THE SOCIETY FOR THE PROTECTION OF ANCIENT BUILDINGS
37 Spital Square London E1 6DY Telephone 020 7377 1644 info@spab.org.uk

Our ref: LS/23748/SPAB/13
Application ref: 3/2013/0029

HESKETH END FARM, CHIPPING

**1:50 (A1) PH/JD/100
 NOVEMBER 2012**

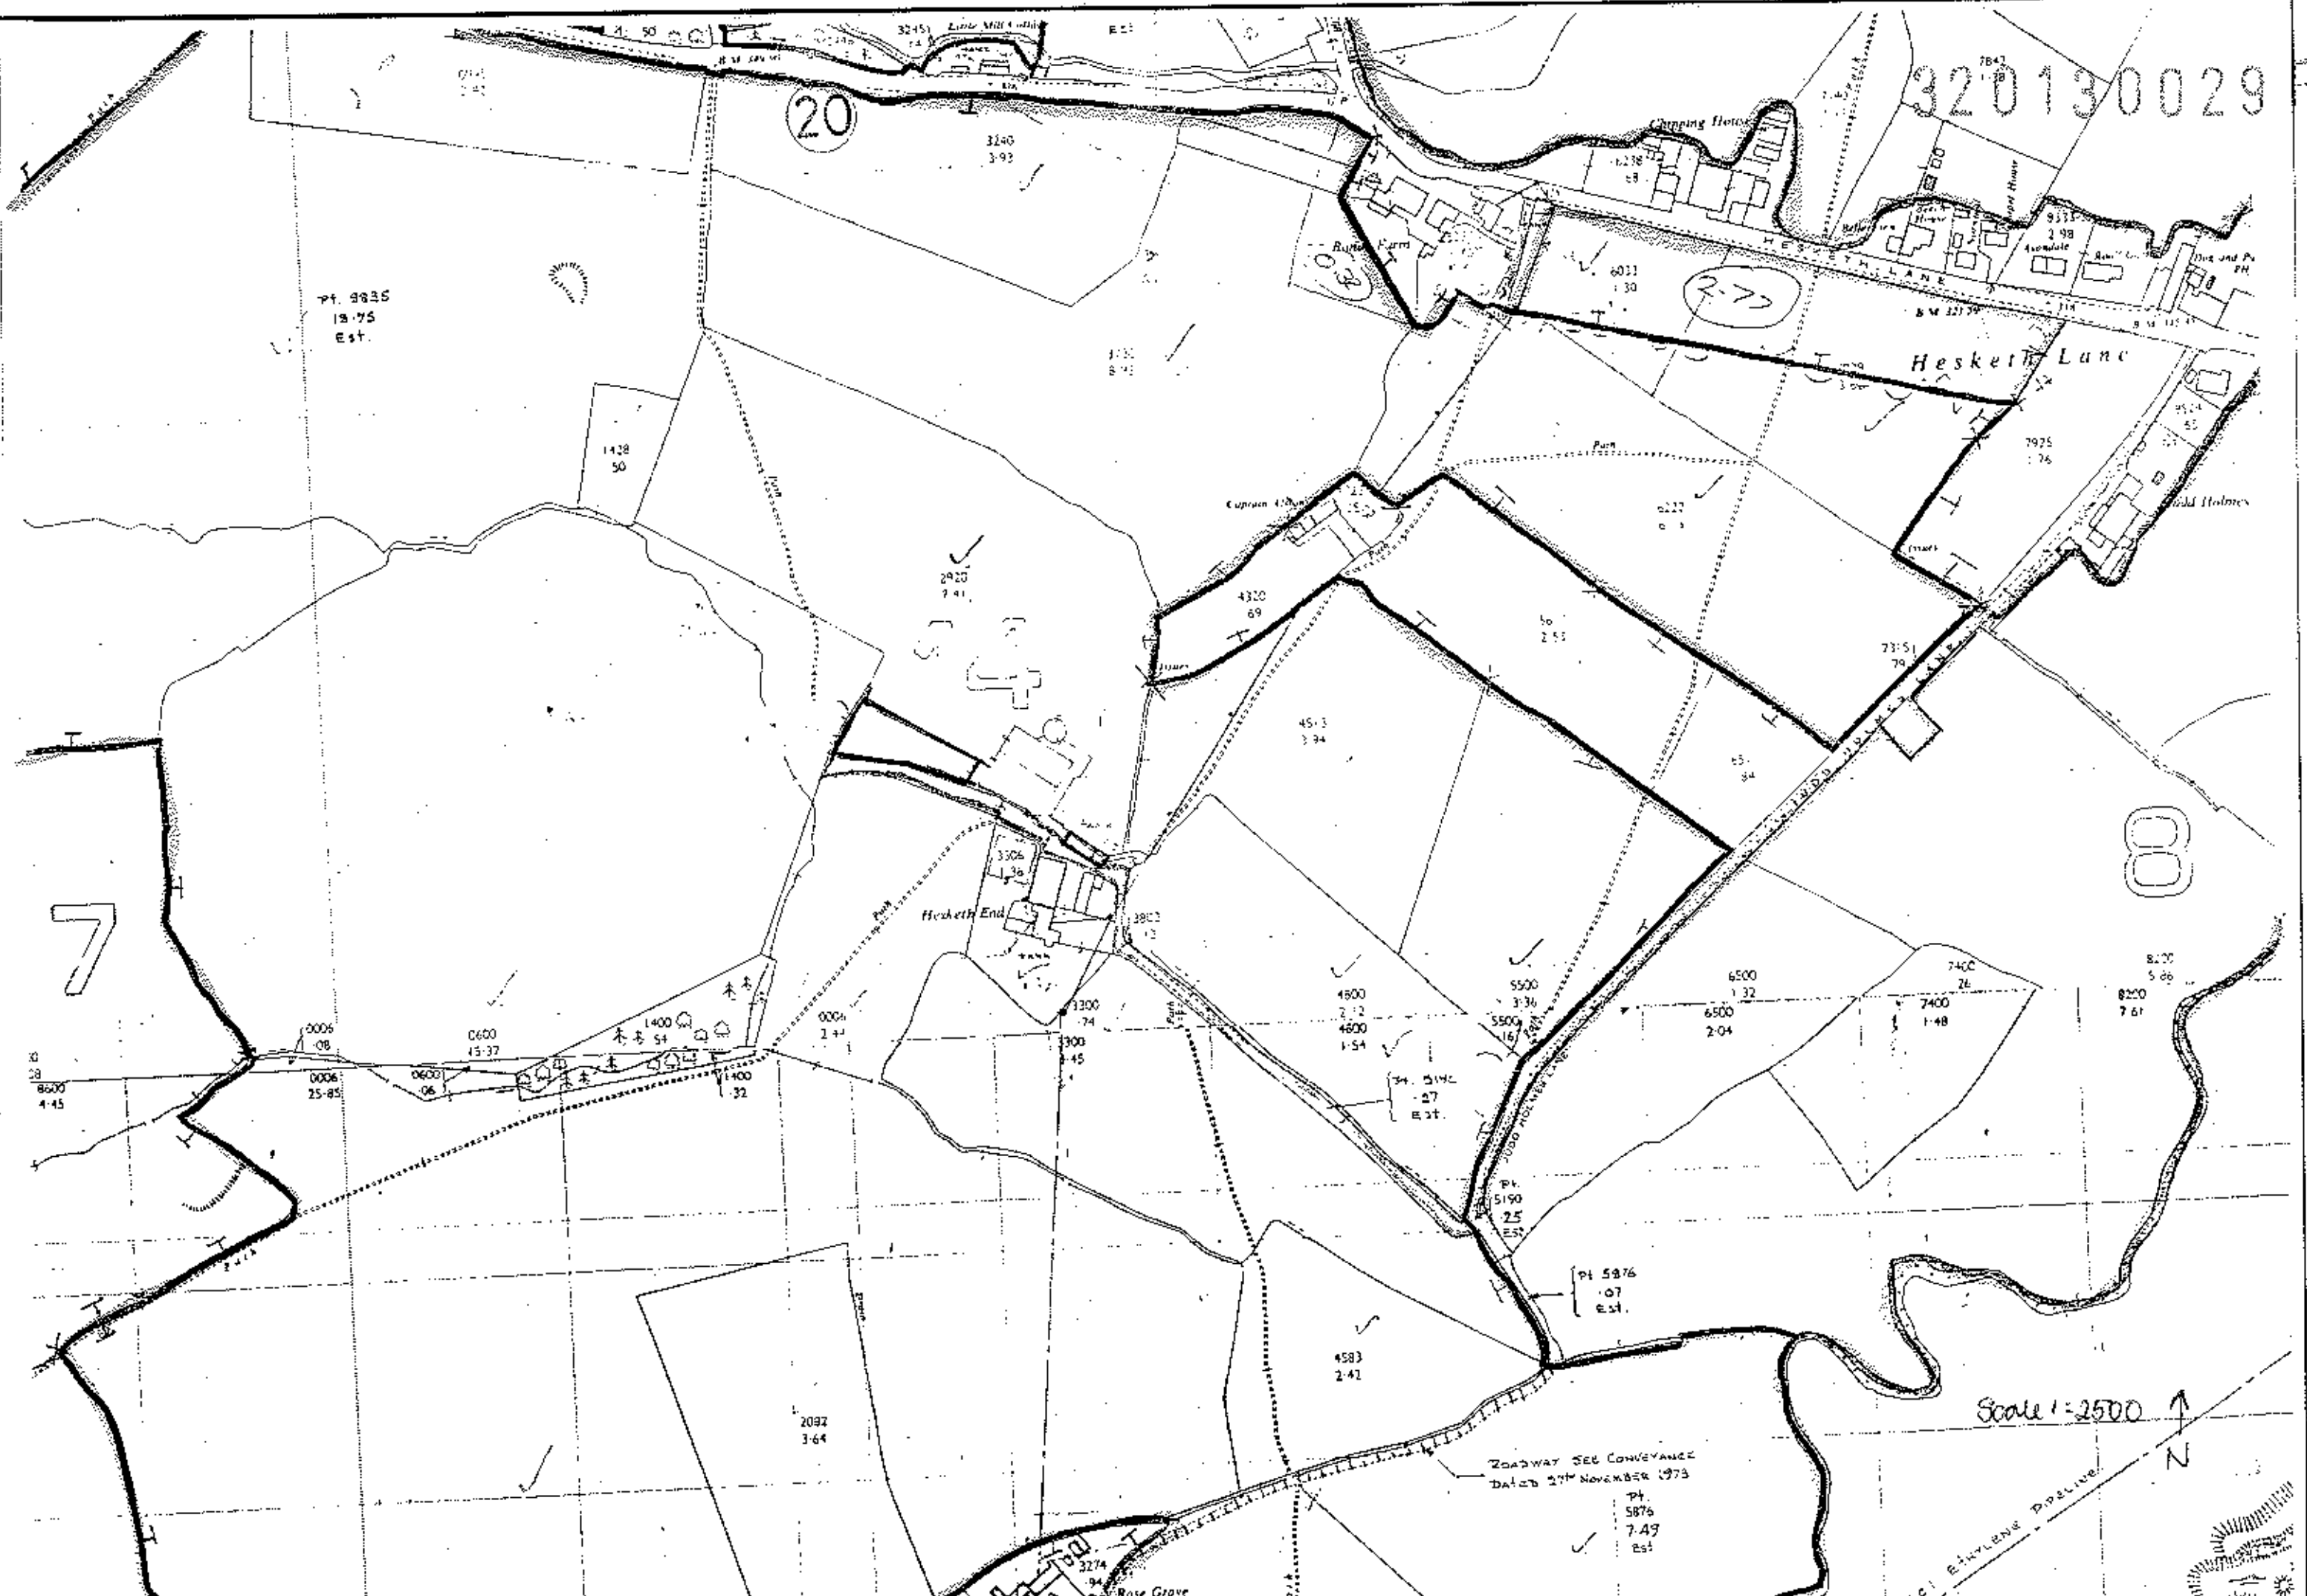
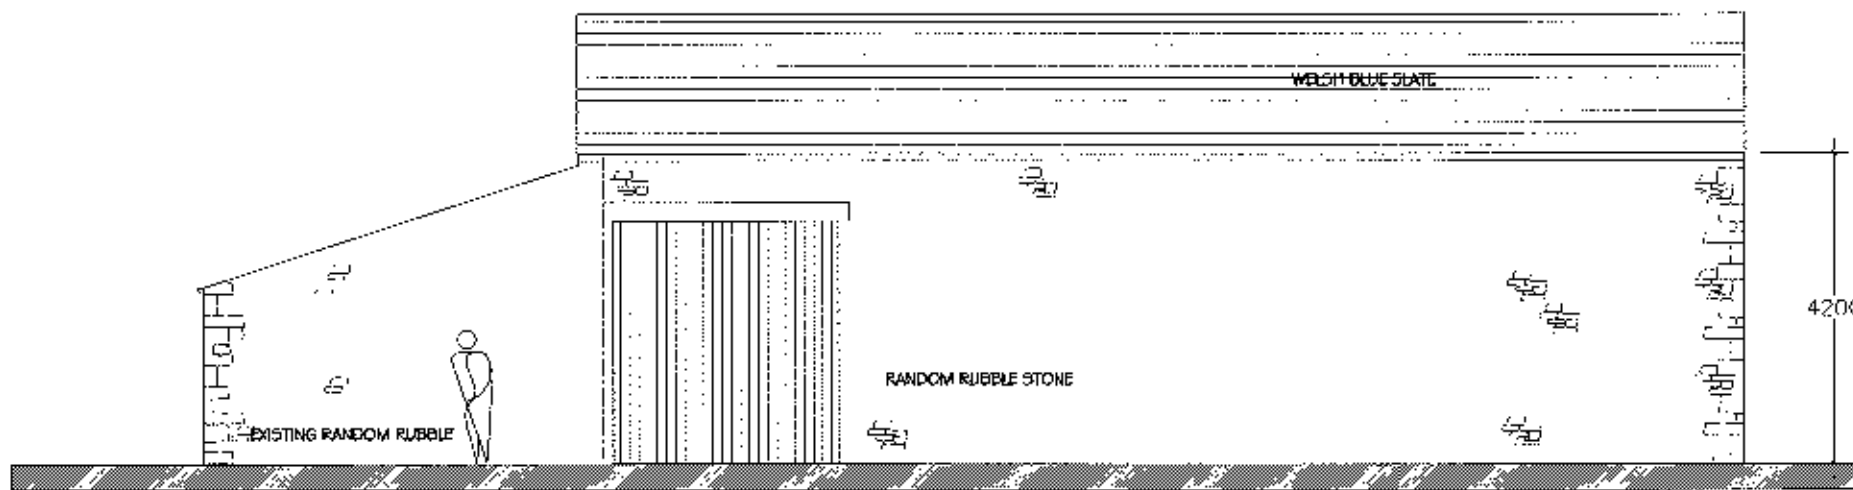
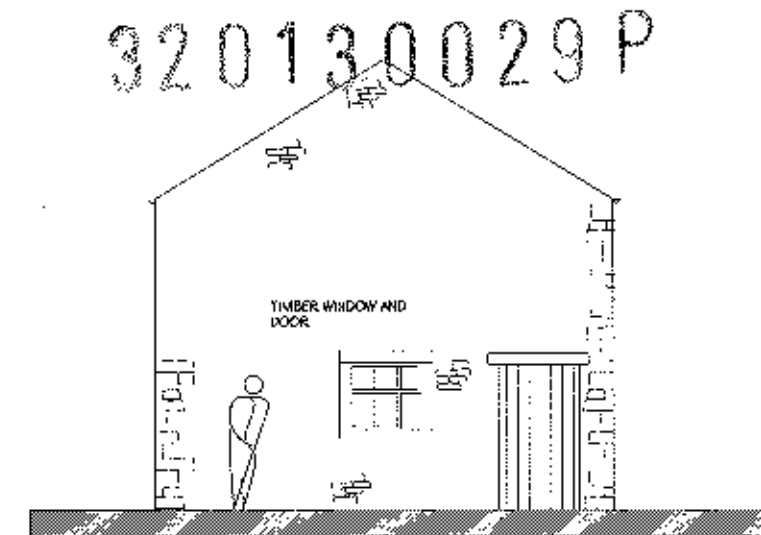
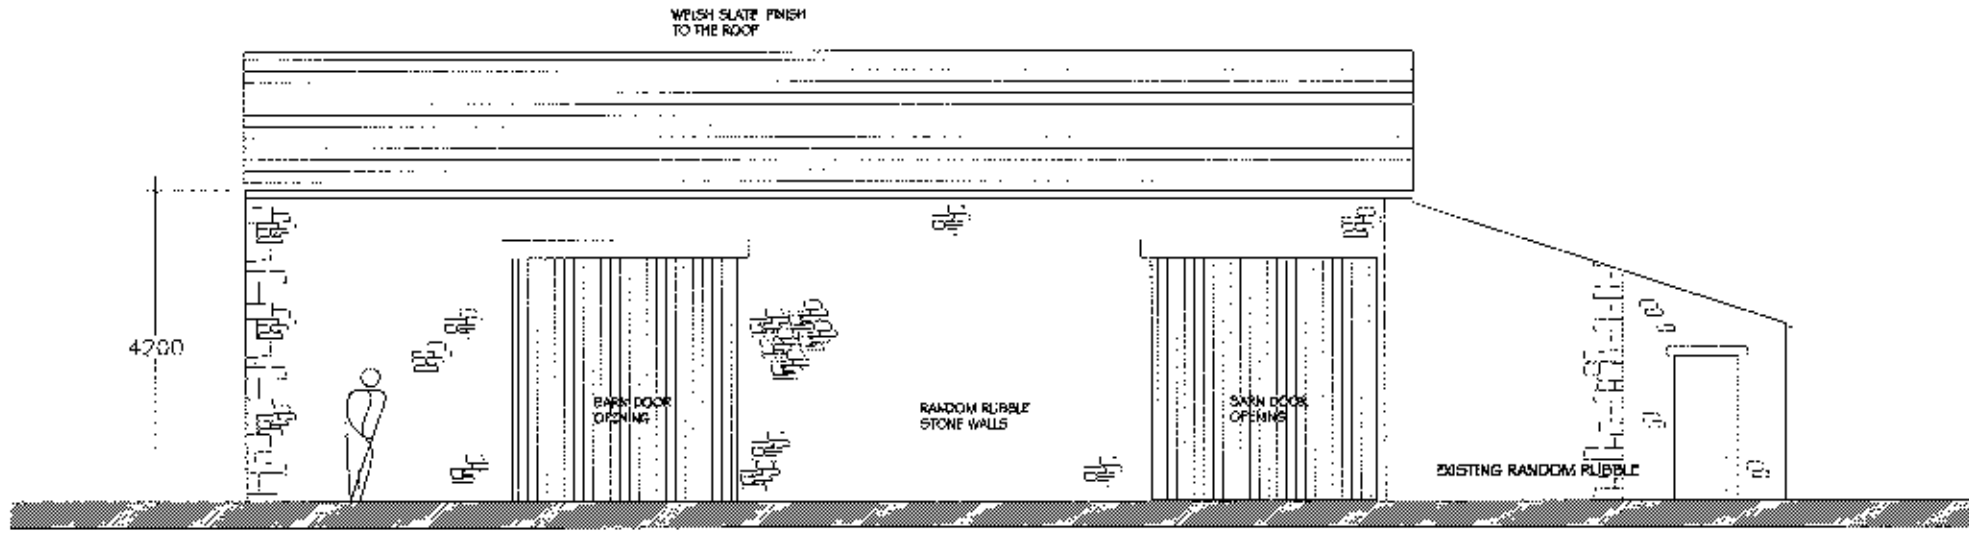
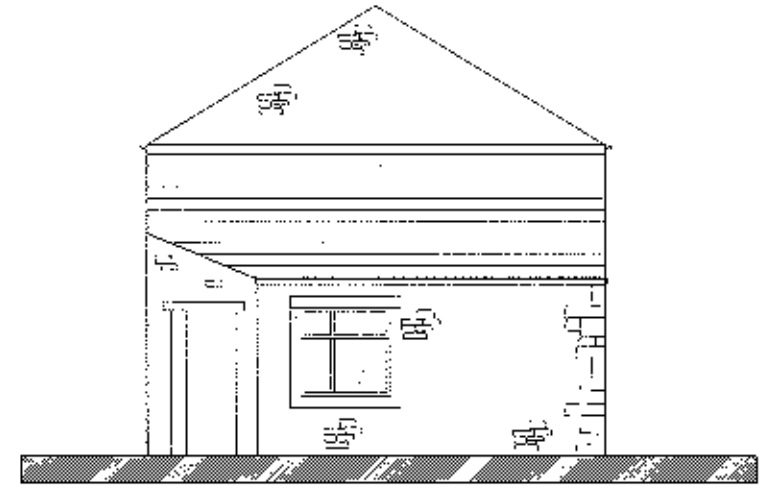
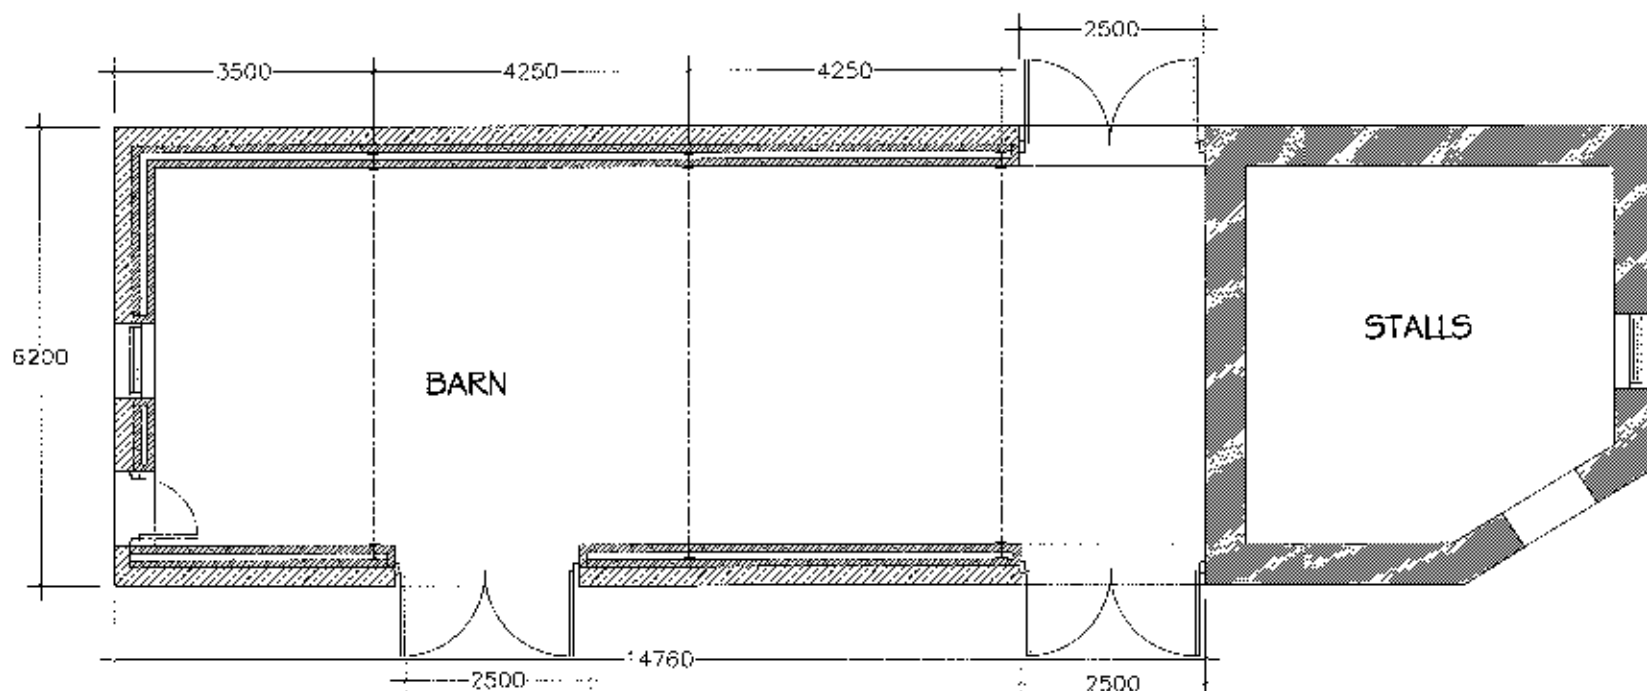
Having examined the documents supplied, we acknowledge the group value of the farm buildings, and are satisfied that the context of the group should be maintained if at all possible. However, the SPAB are very uncomfortable with the proposed approach to rebuilding, as this is effectively producing a 'fake'. We therefore object to the current proposals and urge the applicant to reconsider their approach to this building.

Authenticity is to be valued highly, and enclosing a steel frame and blockwork walls with a random rubble cladding is far from being a traditional approach to building, and should be discouraged. We can see no structural or technical merit in this approach, as the stone walls can be built of sufficient thickness to support a basic timber roof truss, as they were in the first instance. The wall survives in enough extent in places to give a good guide as to the thickness, and there should be ample stone from what was used originally to achieve effective results.
